City of Portland, Maine - Building or Use Permit Application

Permit No: 04-1764	Issue Date:	CBL: 026 F008001
------------------------------	--------------------	----------------------------

Location of Construction: 263 Cumberland Ave	Owner Name: Clarke Merle W	Owner Address: 40 Portland Pier #2	Phone:
Business Name:	Contractor Name: Ron Johnson	Contractor Address: PO Box 445 Portland	Phone 2077872732
Lessee/Buyer's Name	Phone:	Permit Type: Alterations - Commercial	Zone:

Past Use: commercial - legal use is 15 residential units only	Proposed Use: Commercial Replace & repair Fire Escape - 15 residential units only	Permit Fee: \$93.00	Cost of Work: \$8,000.00	CEO District: 1
Proposed Project Description: Replace & repair Fire Escape		FIRE DEPT: <input type="checkbox"/> Approved <input type="checkbox"/> Denied	INSPECTION: Use Group: Type	
		Signature:	Signature:	
		PEDESTRIAN ACTIVITIES DISTRICT (P.A.D.)		
		Action <input type="checkbox"/> Approved <input type="checkbox"/> Approved w/Condition <input type="checkbox"/> Denied		
		Signature:	Date:

FINE ESCAPE LANDING TO GROUND
263 Cumberland Ave

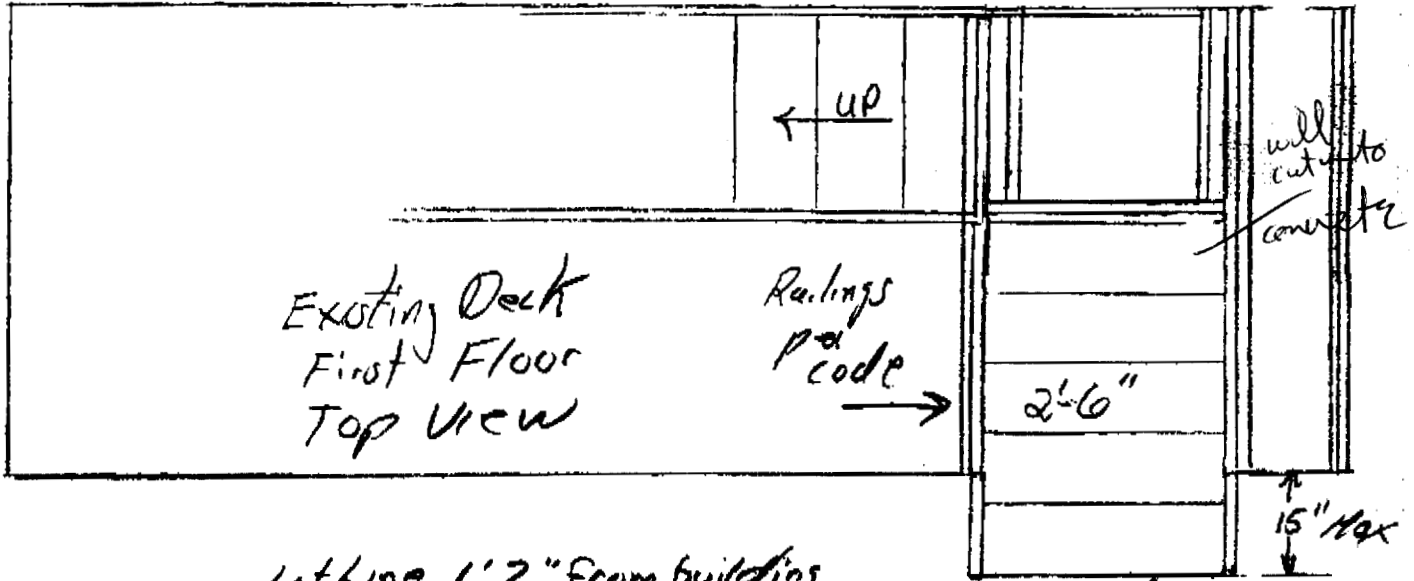
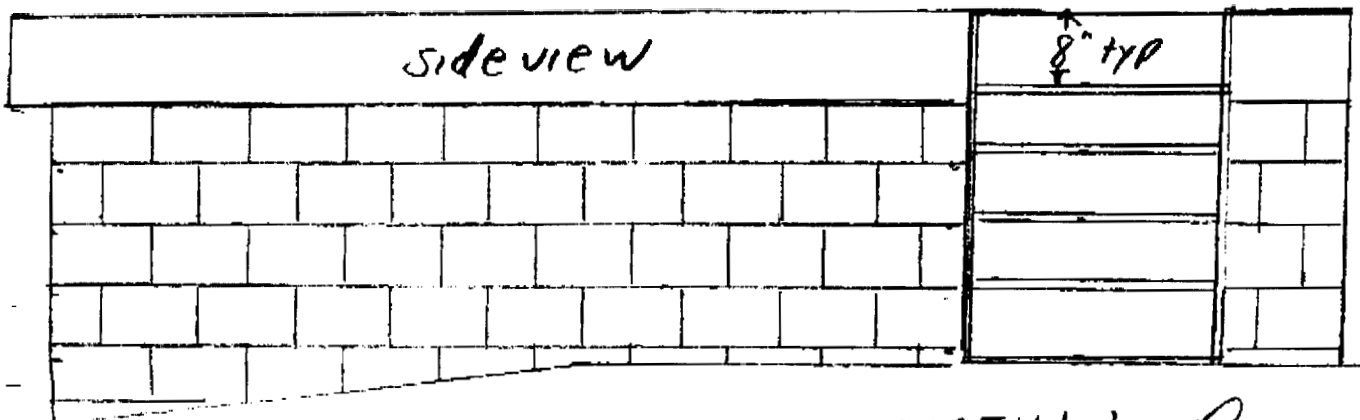
12/22/04 He only has 19" to the real property line per survey by Northeast Civil Solutions. - he is now working on a revised plan

12/30/04 received a revised site plan showing the new stairs will be 4" from the property line - maybe ok under 14-440 - we need to discuss with Lt. Mac

1/6/05 Lt. Mac has approved the plans as proposed which are the minimum needed - ok under 14-440
